ENGLISH HERITAGE  
NORTH WEST REGION

Our ref: L00115400

**Notifications under Circular 01/2001, Circular 08/2009 & GDPO 1995**  
**TALBOT HOTEL, 5 TALBOT STREET, CHIPPING, PRESTON, LANCASHIRE, PR3**  
**2QE**  
**Application No 3/2011/0821**

Proposed Ground Floor Site Plan

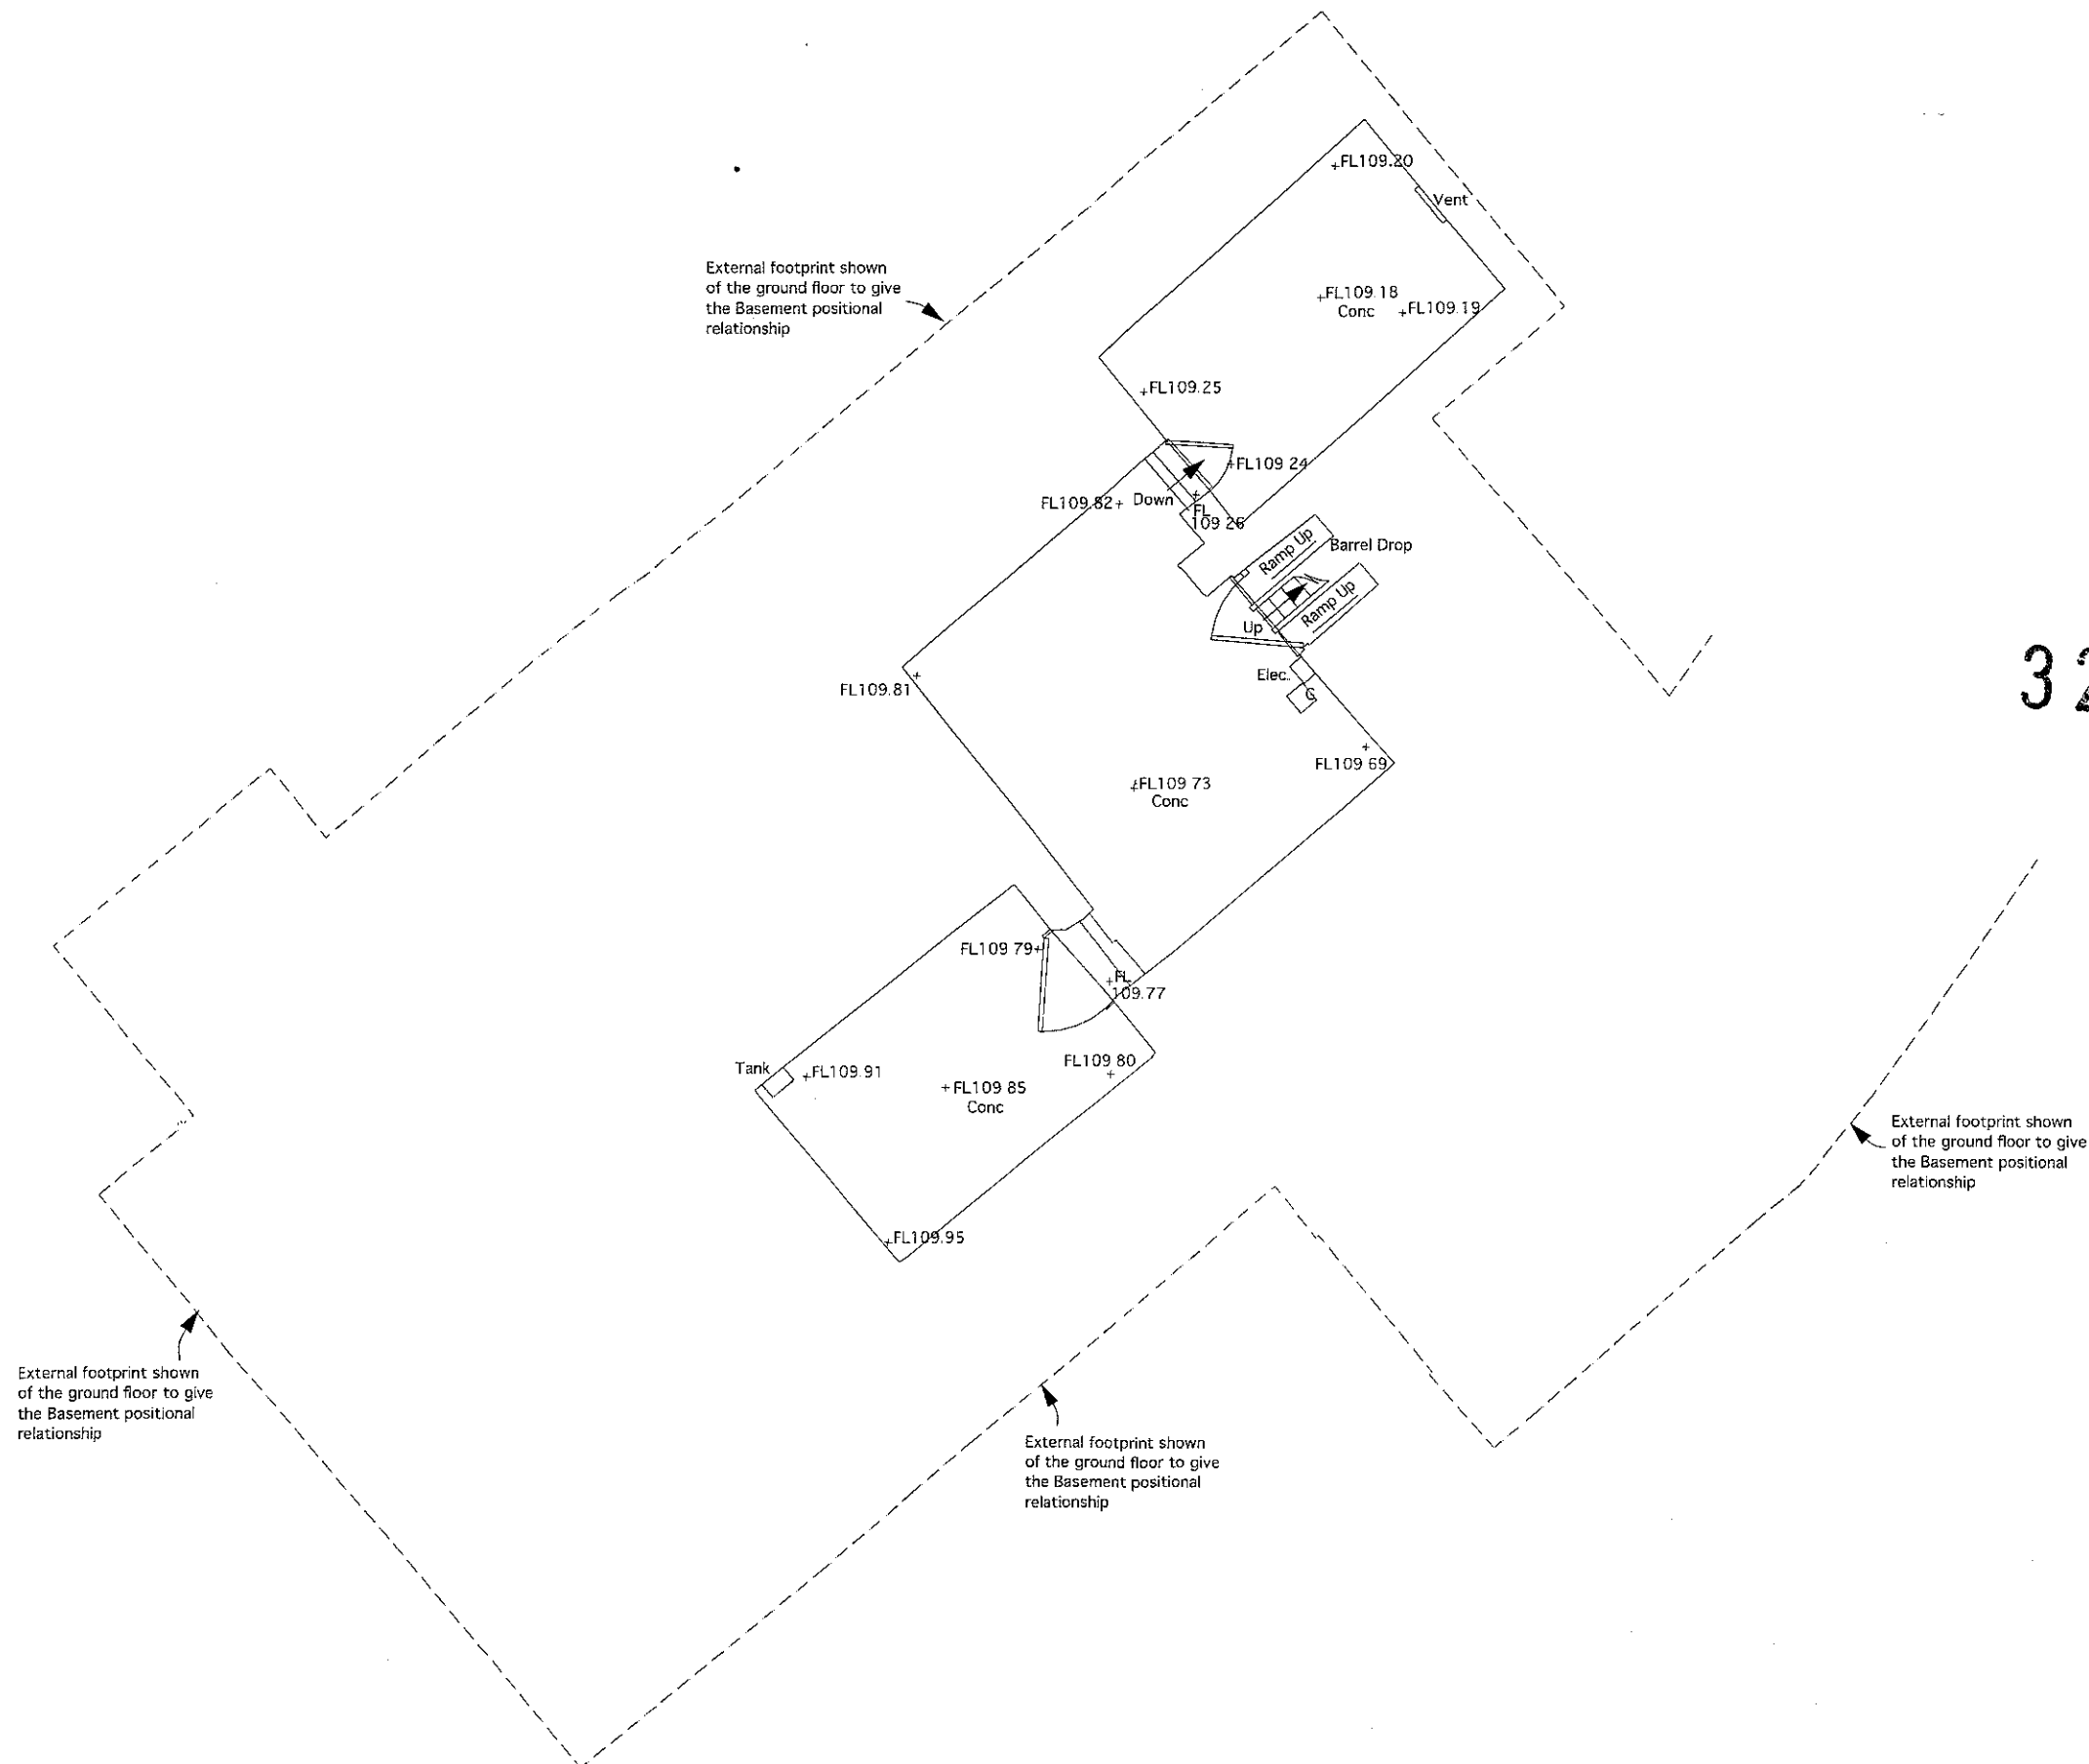
The conversion of the Stables and barn into an ancillary accommodation block containing 11no. ensuite bedrooms would require a particularly intensive level subdivision, alteration and upgrading of fabric which would fundamentally alter the character of the Grade II listed building and have a major impact on its historic interest. We therefore question whether as part of the process of developing the Business Plan for the site, the option of using the Stables and barn for alternative uses such as a function room and / or restaurant has been considered.

The barn is 5 bays wide and therefore large than average size and the open character of the interior is an important part of the significance of the Grade II listed building. Introducing a new open plan / flexible space into the building would have the benefit of preserving the character of the interior of the interior and be more in-keeping with its original function. This would also reduce the need for an intensive level subdivision, upgrading of internal walls and introduction of services, pipework, drainage, serving etc, as currently proposed and could perhaps also involve the re-instatement of features of interest. This could also be seen as a public benefit as it would allow greater public access to the building and create a more characterful function room with an active frontage to the street.

Proposed First Floor Site Plan

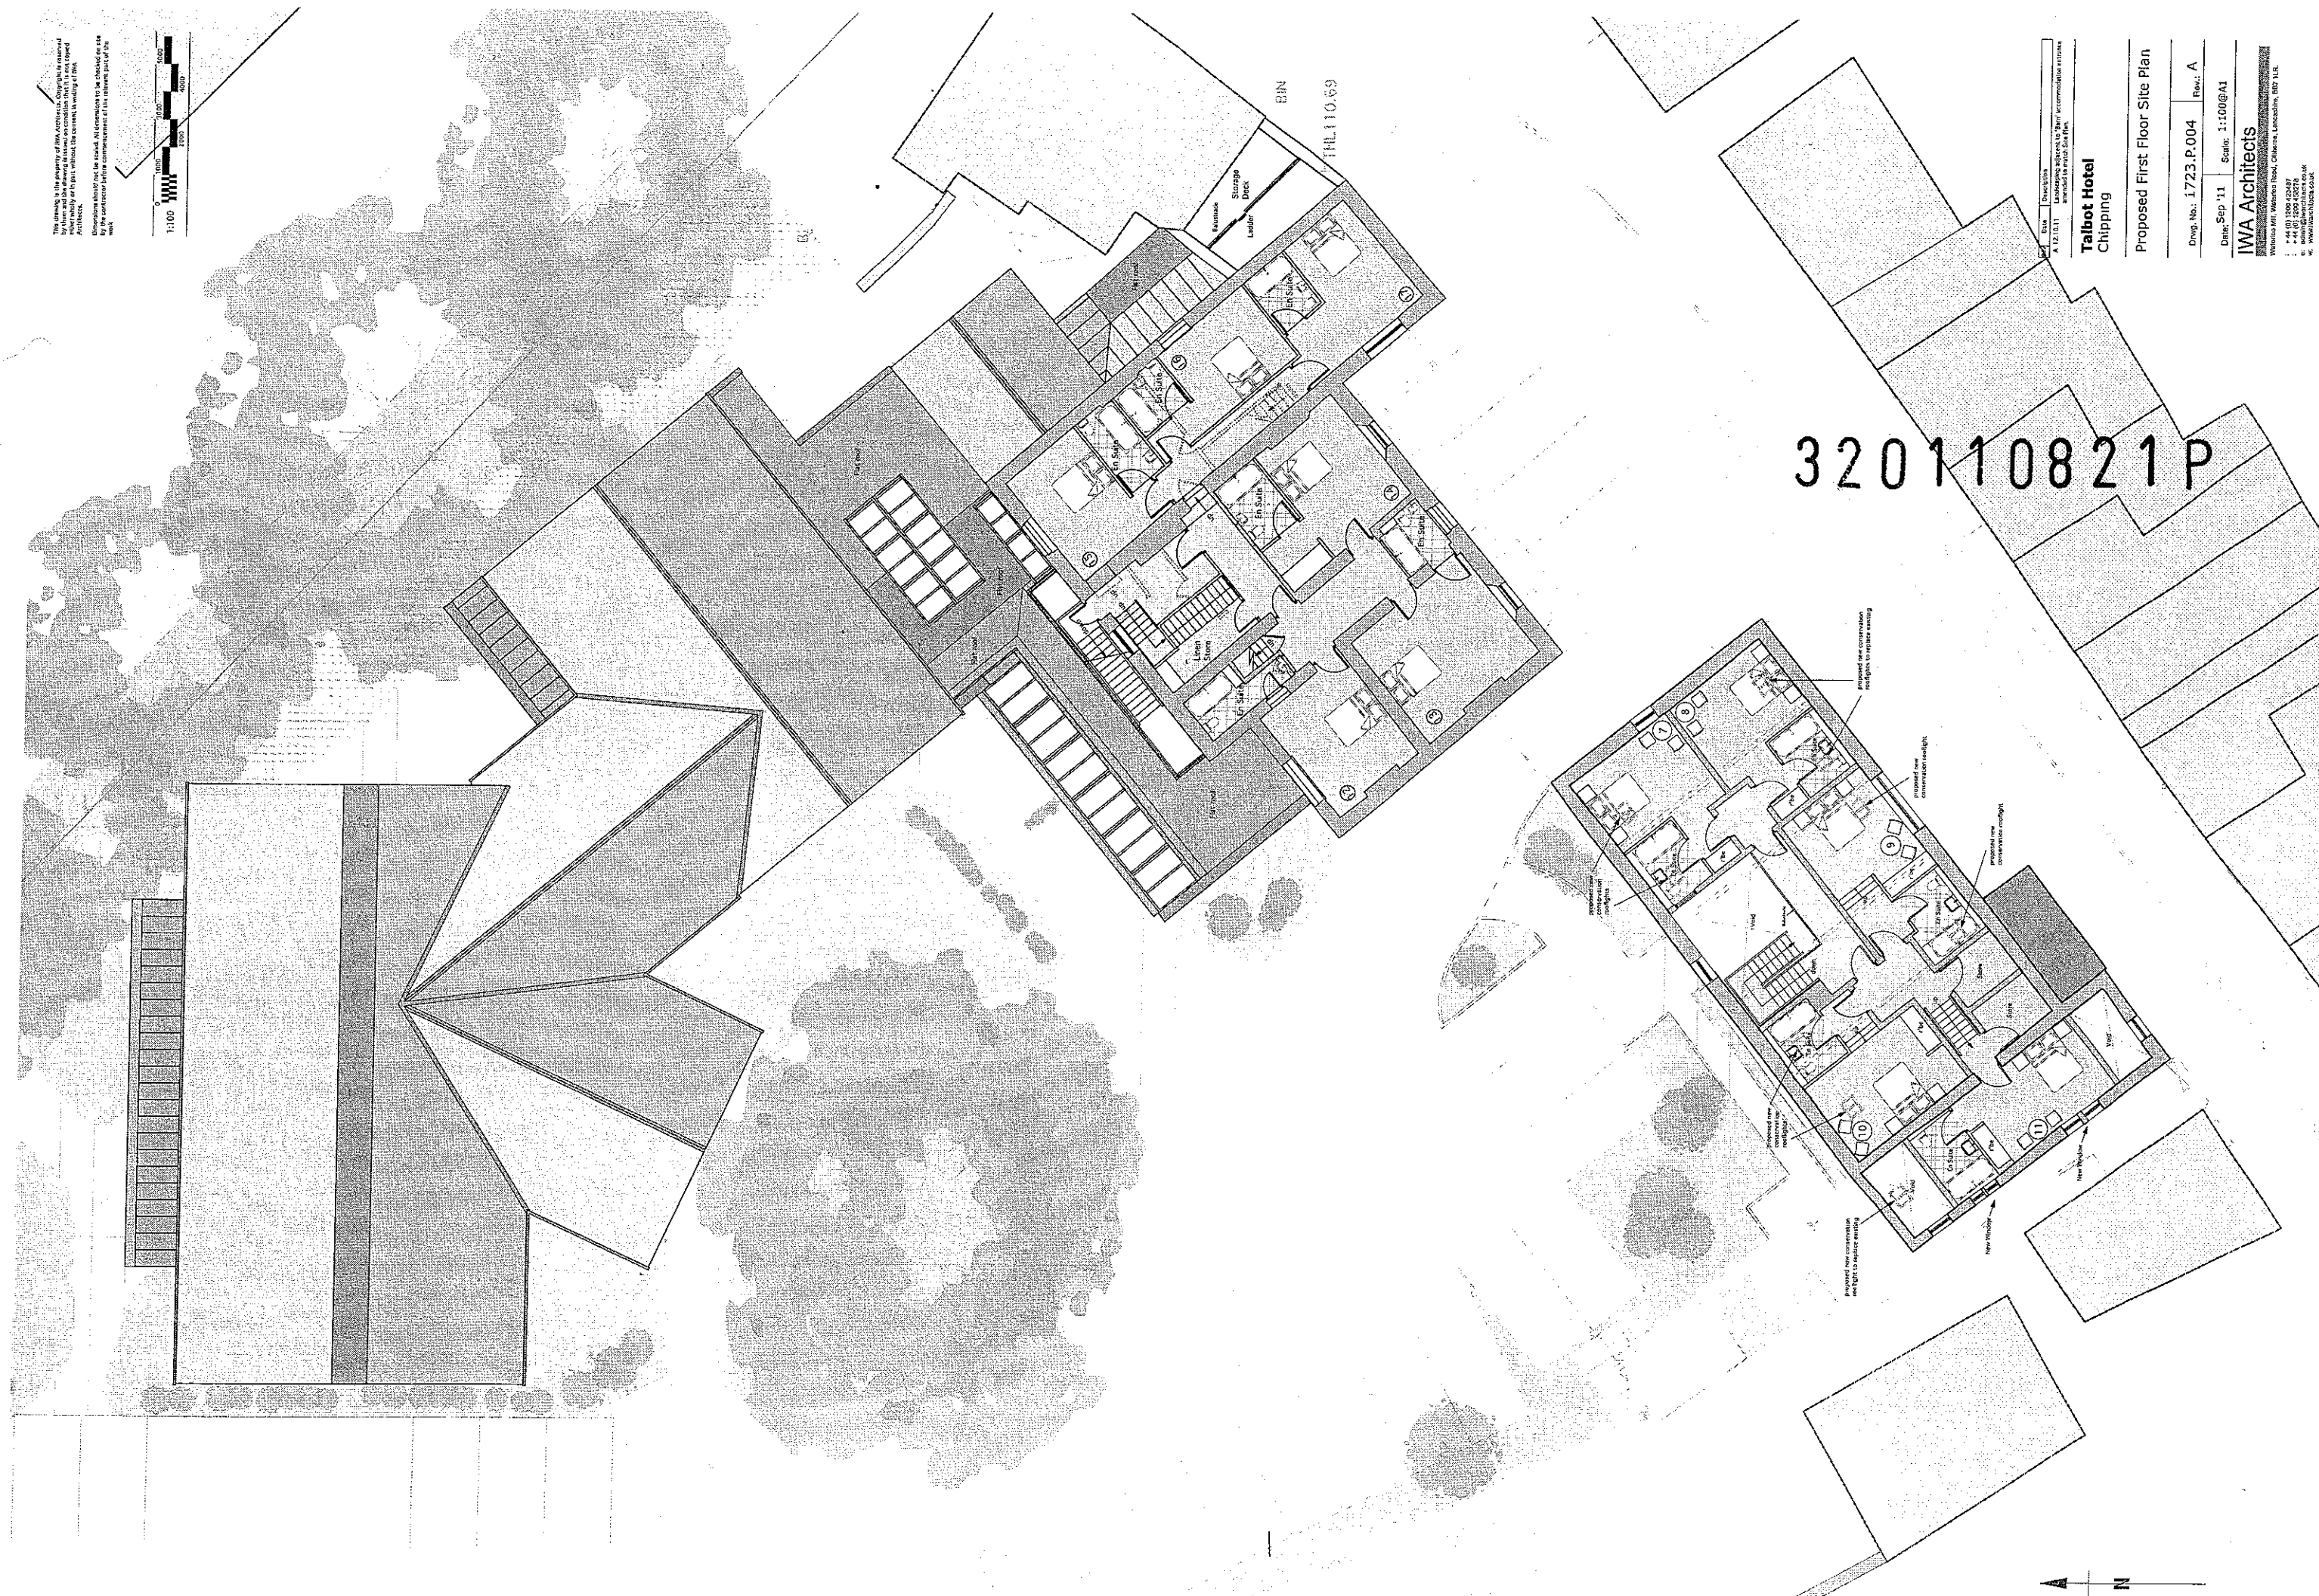
We welcome the retention of the existing historic staircase, however, the proposed new staircase external staircase and rear glass box extension at first floor level will have an impact on the rear elevation of the building. We urge that you should be satisfied that the need for an additional staircase and internal space to the rear has been adequately justified.
